**WEST SUSSEX COUNTY COUNCIL
STRATEGIC PLANNING CONSULTATION**

SUBJECT: P/76/16/PL - Construction of a building for the packaging, preparation & distribution of fresh foods with ancillary accommodation associated with the existing horticultural business, revisions to internal access road, car parking & hardstanding areas & landscaping & provision of a wetland. This application affects the setting of Listed Buildings.

LOCATION: Sefter Farm, Pagham Road, Bognor Regis, West Sussex, PO21 3PX.

**WEST SUSSEX COUNTY COUNCIL
STRATEGIC PLANNING CONSULTATION**

| 1603        | P102        | 12    |      |

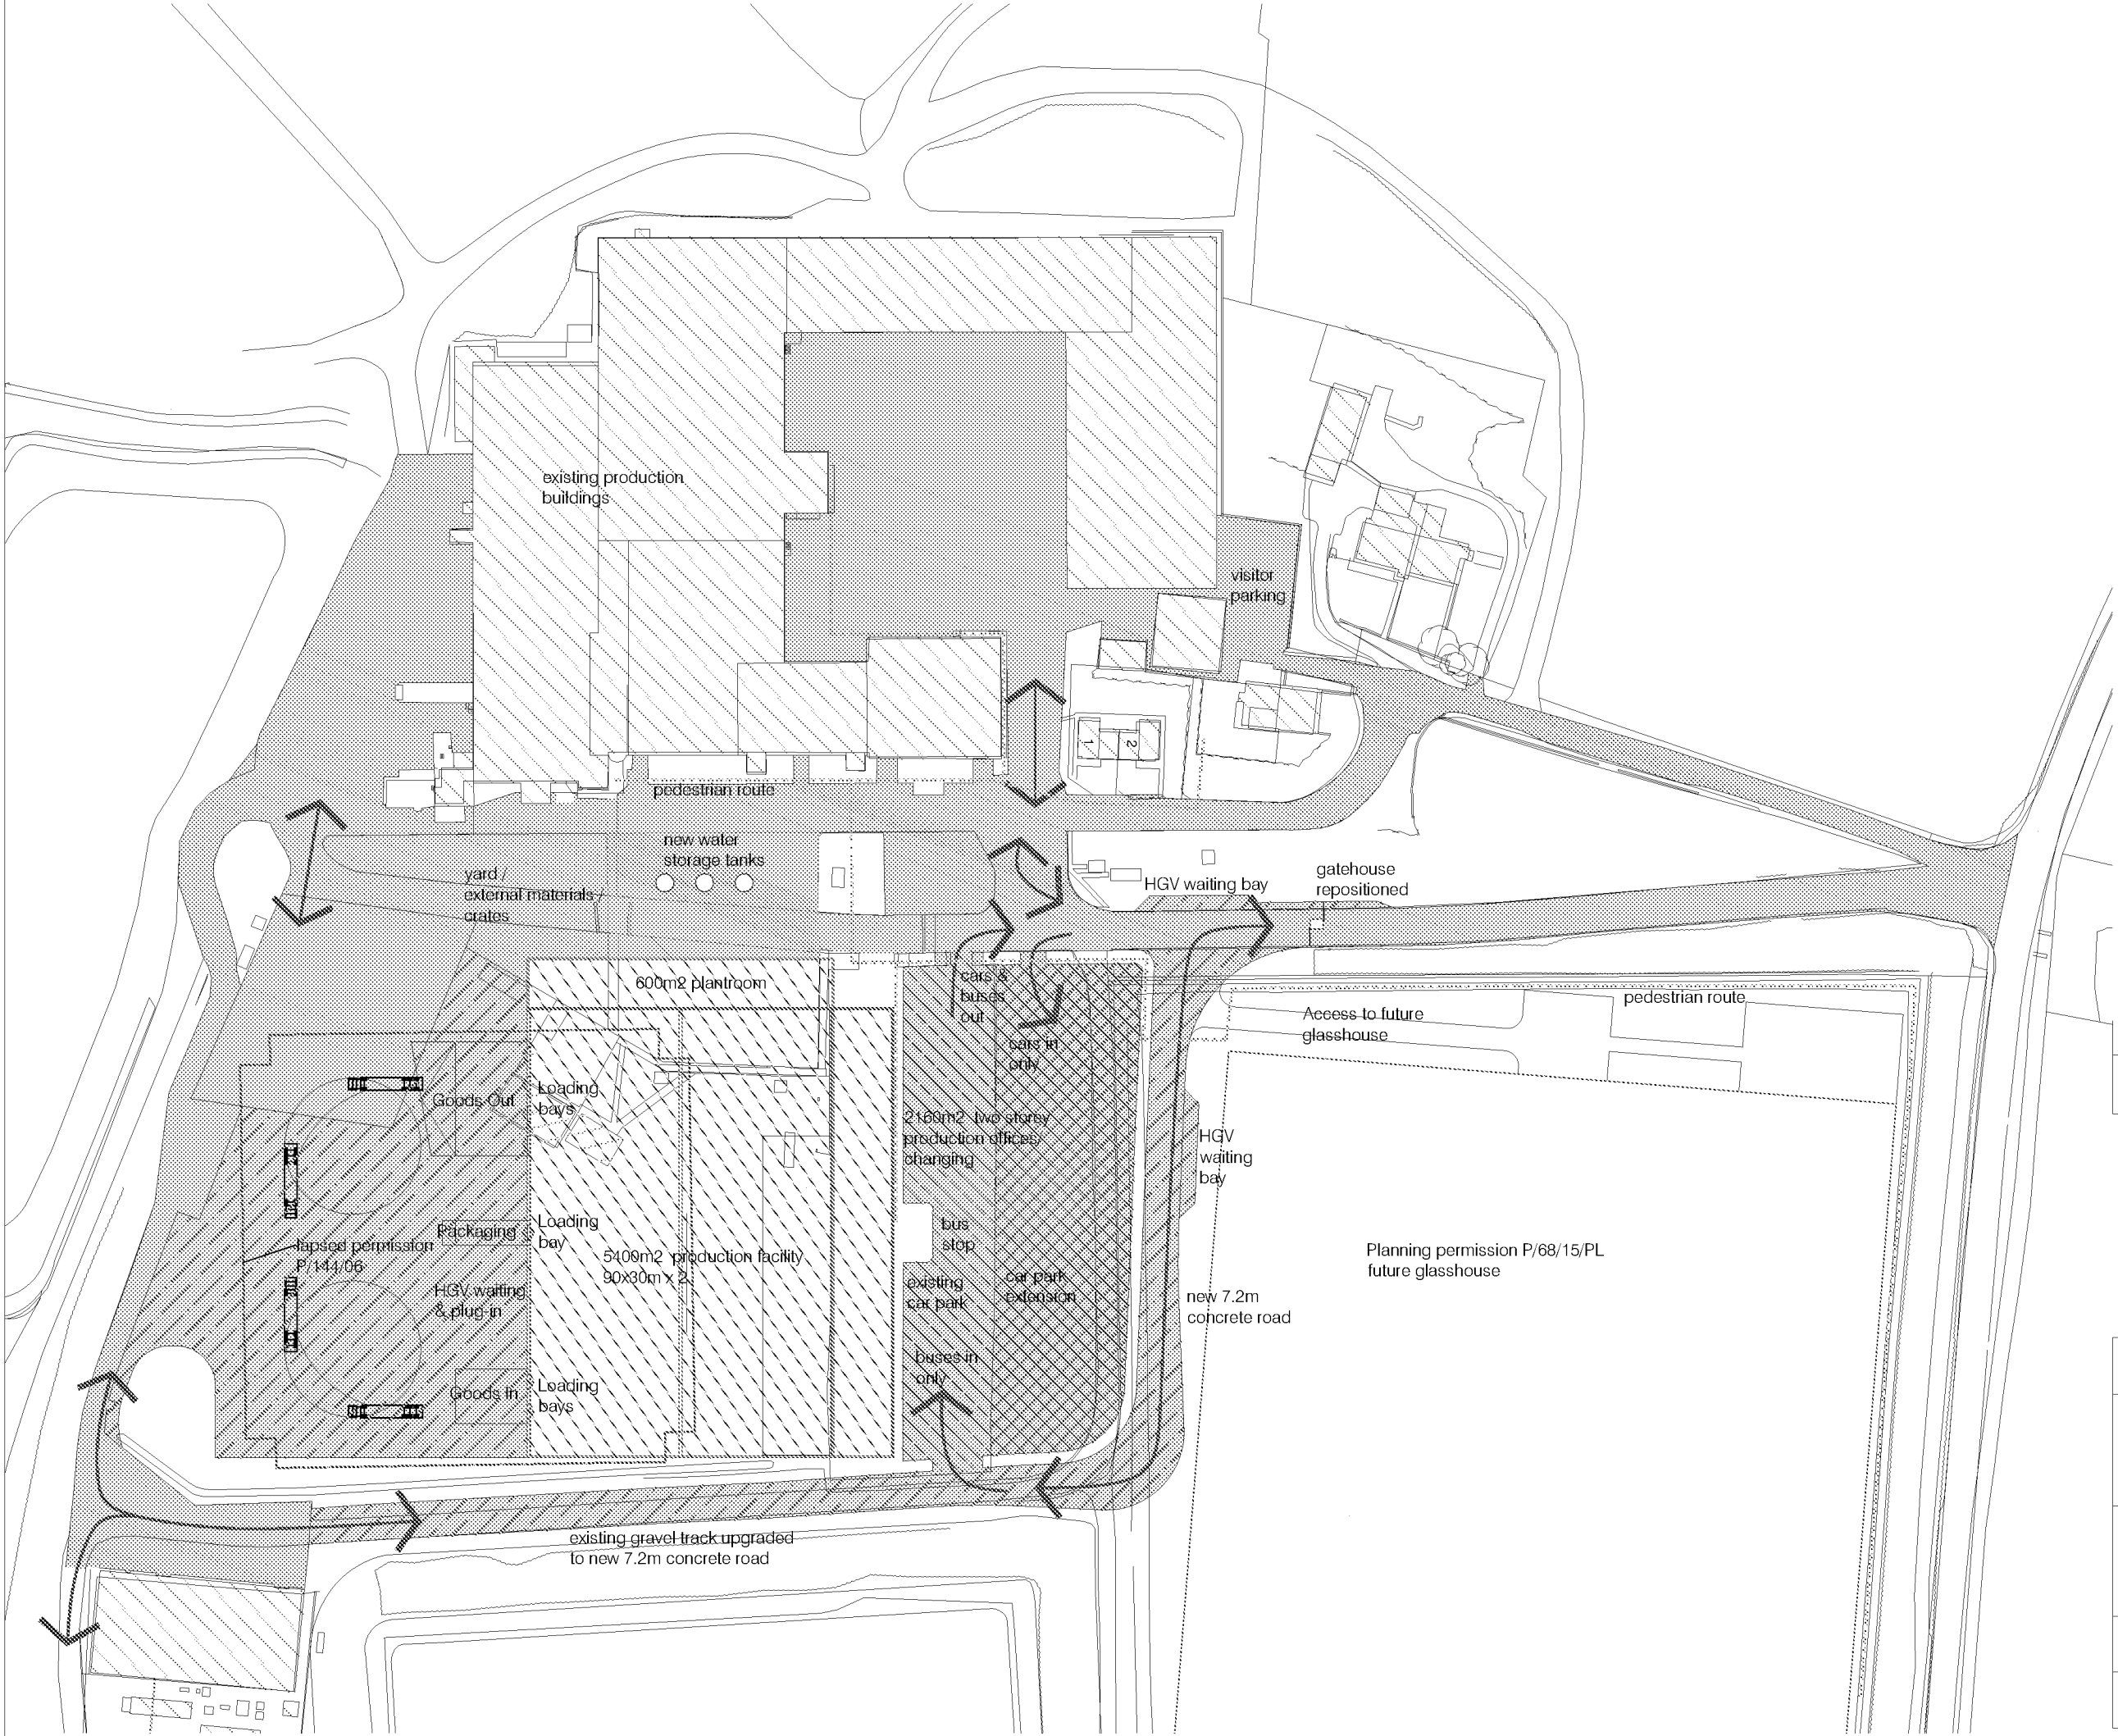
- Office facility – 1,857sqm (although 2,160sqm is quoted on Drg. No. P102 Rev. 12 provided by Curtis Leeves Technical Ltd.)
- Pack House – 5,887sqm (although 5,400sqm is quoted on Drg. No. P102 Rev. 12)
- **Total roof area of new buildings – 7,744sqm (7,560sqm if using the figures quoted from Drg. No. P102 Rev. 12)**

Both existing and proposed parking and turning for cars is shown in one location east of the new building. Parking and turning for HGVs and/or delivery vehicles is shown to the rear (west) of the building. Although the applicant states that the uses proposed are sui generis, if B1 (office) and B8 (storage and distribution) planning uses are used, the WSCC Parking Guidance document suggests that the number of spaces should be as follows:

From both on-site observation and scrutiny of 'Google Streetview', the existing car park currently provides about 130 car parking spaces and appears to be already well-used. However, spaces are not marked out and are on gravel (or similar). The applicant does provide a plan showing the location of the proposed building and the car parking moved eastwards. However, as spaces are again not marked out, no assessment can be made as to how many spaces will be available for use following redevelopment. The applicant states that the existing provision will be adequate for the new proposal although again, this needs to be qualified by the applicant. The floor area of the existing buildings (including those consented but not built yet) should be provided by the applicant to enable further consideration of parking requirements.

- Office facility – 1,857sqm (although 2,160sqm is quoted on Drg. No. P102 Rev. 12 provided by Curtis Leeves Technical Ltd.)
- Pack House – 5,887sqm (although 5,400sqm is quoted on Drg. No. P102 Rev. 12)
- **Total roof area of new buildings – 7,744sqm (7,560sqm if using the figures quoted from Drg. No. P102 Rev. 12)**

Both existing and proposed parking and turning for cars is shown in one location east of the new building. Parking and turning for HGVs and/or delivery vehicles is shown to the rear (west) of the building. Although the applicant states that the uses proposed are sui generis, if B1 (office) and B8 (storage and distribution) planning uses are used, the WSCC Parking Guidance document suggests that the number of additional spaces should be as follows:

Scrutiny of the submitted plans shows the location of the proposed building and the car parking moved eastwards. The applicant states that the existing provision will be adequate for the new proposal. If it is assumed that the figure of 170 is adequate for the current operations (note that this does not include anything previously approved and not yet built – applicant to provide further information about this) and then one adds a further requirement for the new buildings based on parking guidance, this would suggest that an additional 104 spaces are required, bringing the total amount required to 274.

The applicant's agent, in his letter of 26th September 2016, has explained that the floorspace figures quoted on the application form are the correct ones to use. Therefore, the Highway Authority's consideration of the application is based on the overall figure of **7,744sqm** (1,857 office facility and 5,887sqm pack-house).
